Subject: RE: St Marys Hall, Arundel

RE: Floor at St Marys Hall, Arundel

Lower Level Floor Plan
As Proposed

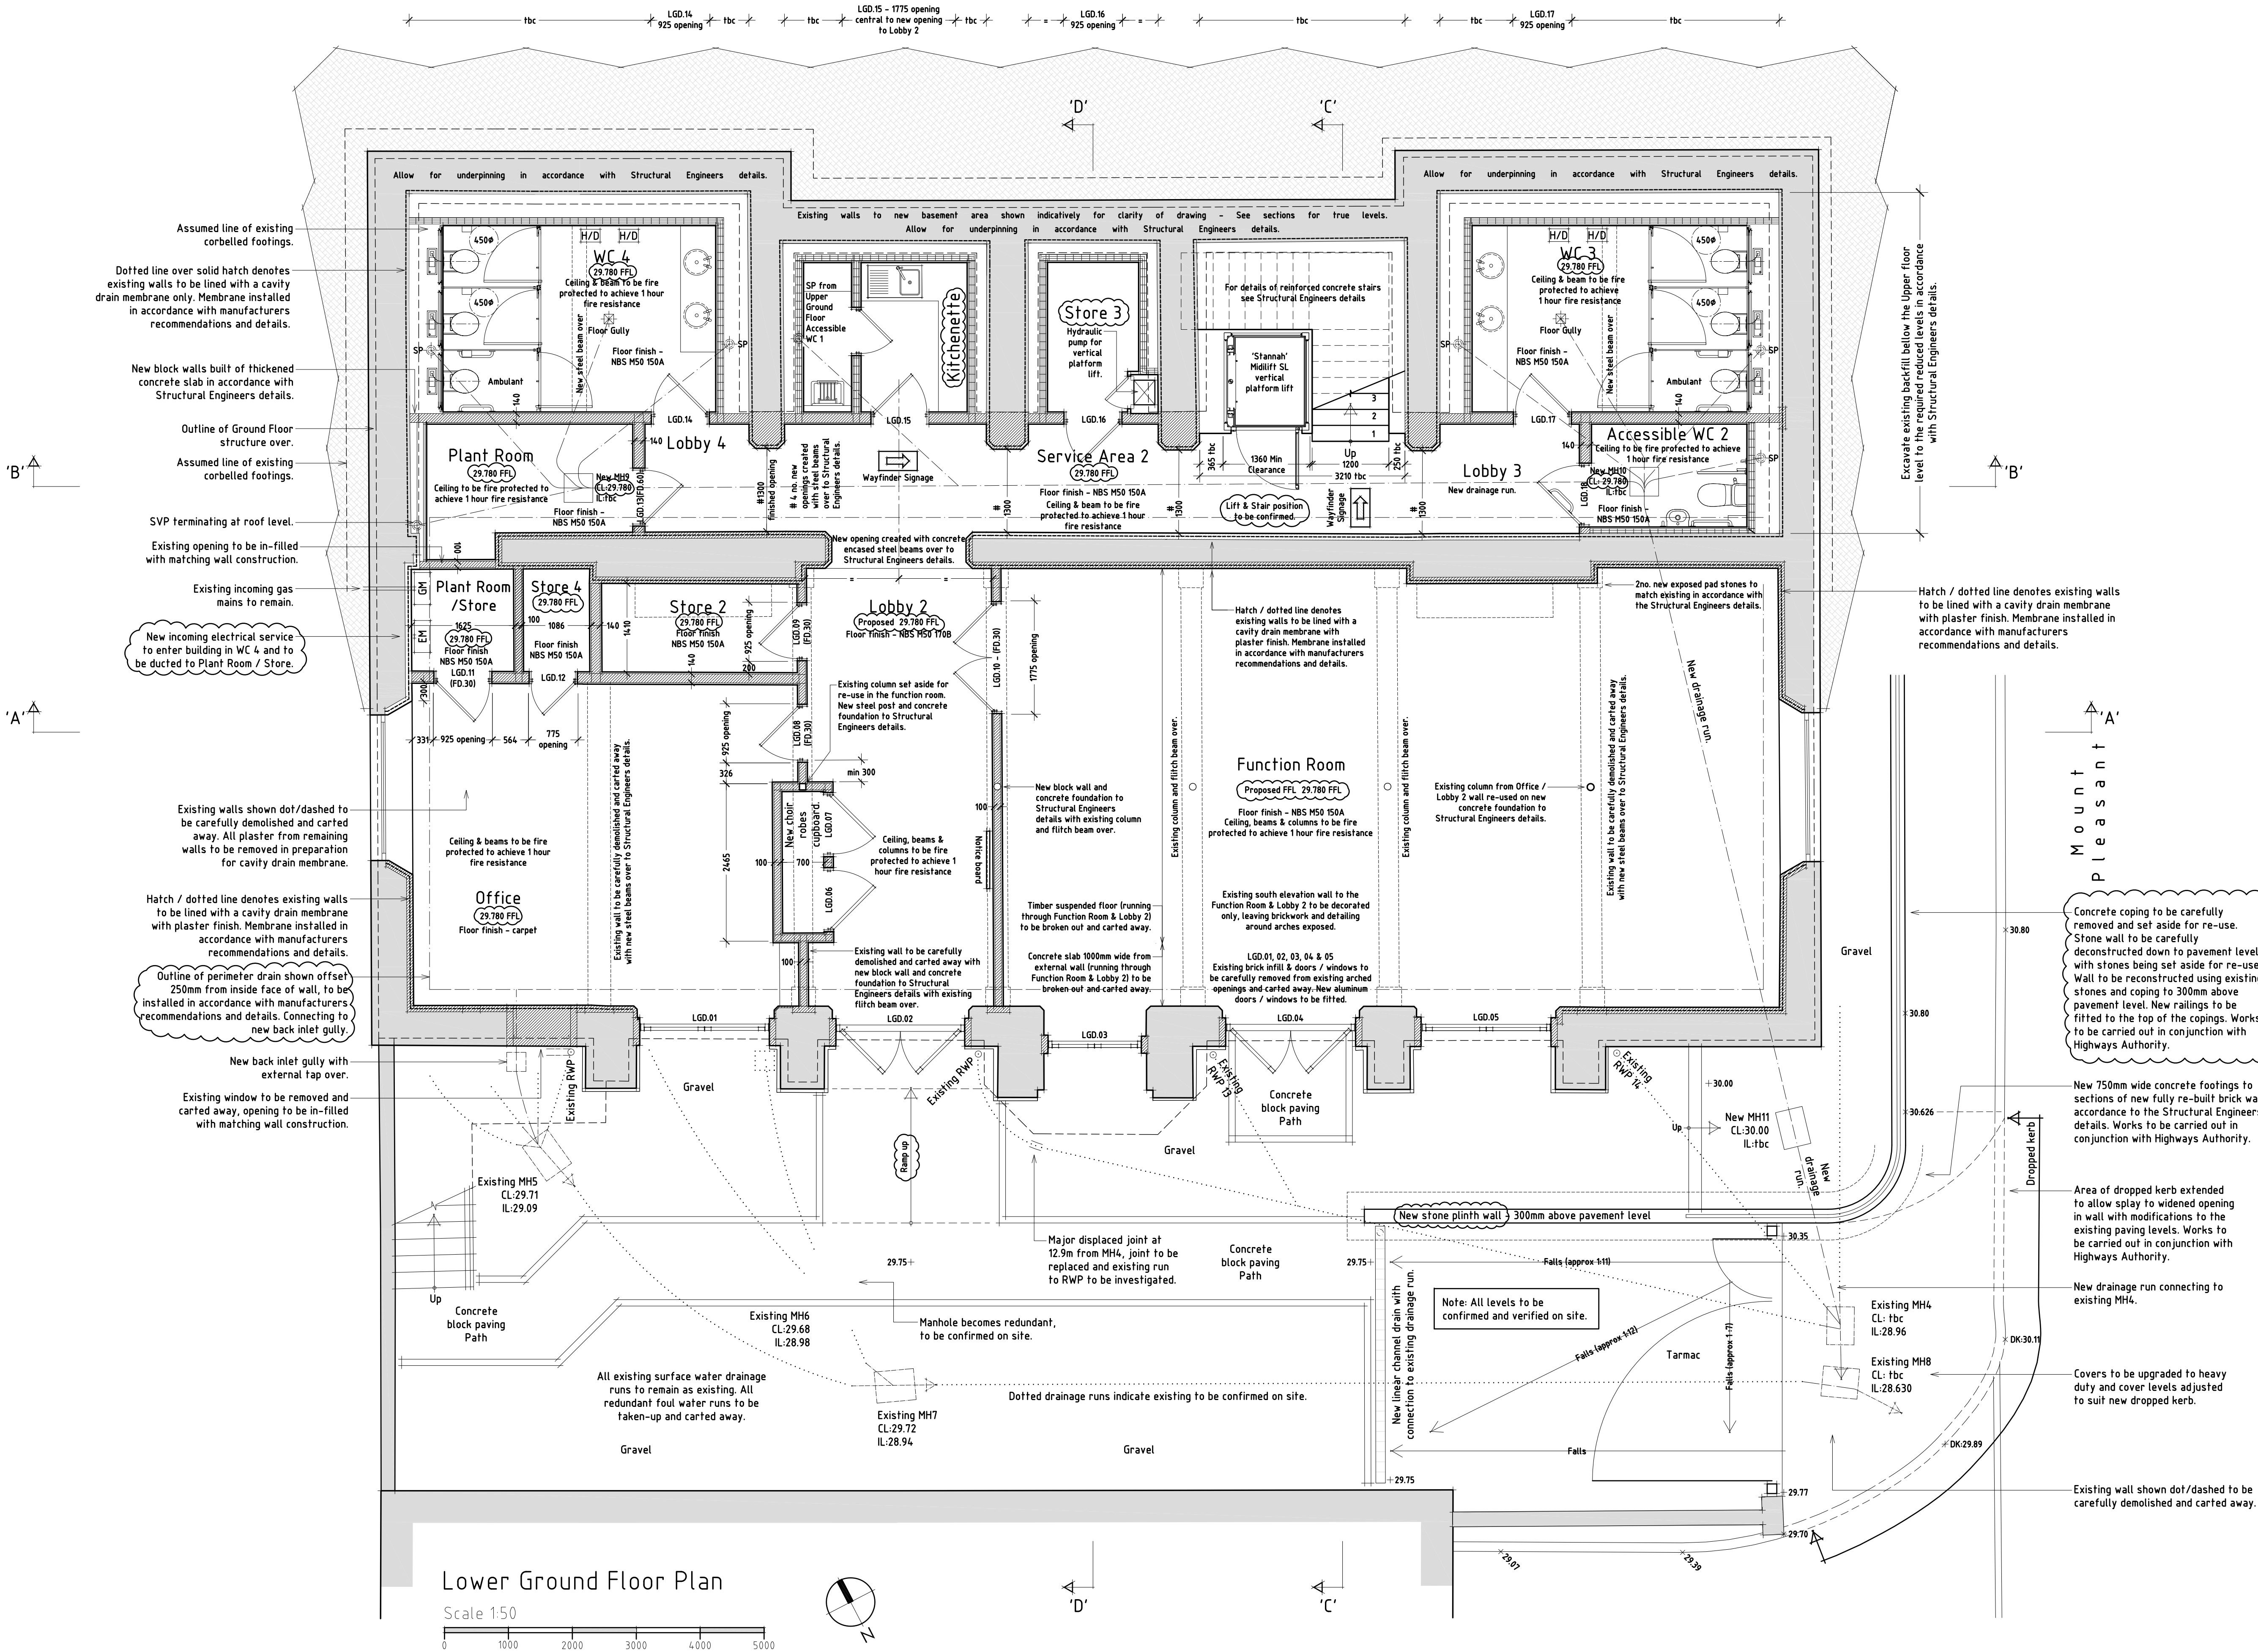
The removal of the floor is important as it results in both the loss of historic fabric and therefore part of the building's significance. In doing so it conflicts with the requirements of PPS5 and the associated guidance which asks authorities to seek to preserve such features. With this in mind there are at least three points that should be raised and considered here. They are as follows:

179. The fabric will always be an important part of the asset's significance. Retention of as much historic fabric as possible is therefore a fundamental part of any good alteration or conversion, together with the use of appropriate materials and methods of repair. It is not appropriate to sacrifice old work simply to accommodate the new.

184. The introduction of new floors into a building or removal of historic floors and ceilings may have a considerable impact on an asset's significance. Certain asset types, such as large industrial buildings, are generally more capable of accepting such changes without unacceptable loss of significance

188. Extant flooring materials will often be of interest in themselves. Additional care is needed on lower floors to ensure that archaeological interest below the finished surface is not adversely affected by proposed works.

Given the appearance and quality of the existing floor, I would have thought it wise to try and preserve it, at least archaeologically. This would enable it to be covered, but would not result in its total loss from the building. Removal and replacement of the floor will require full and convincing justification with regards to the need for a new surface to provide a long term, sustainable use for the building. I am still not sure why this cannot be achieved with the existing floor and a more conventional heating system, but perhaps that can be explained more fully. If this is convincing in that is necessary for the successful reuse of the building then, it could be considered acceptable.
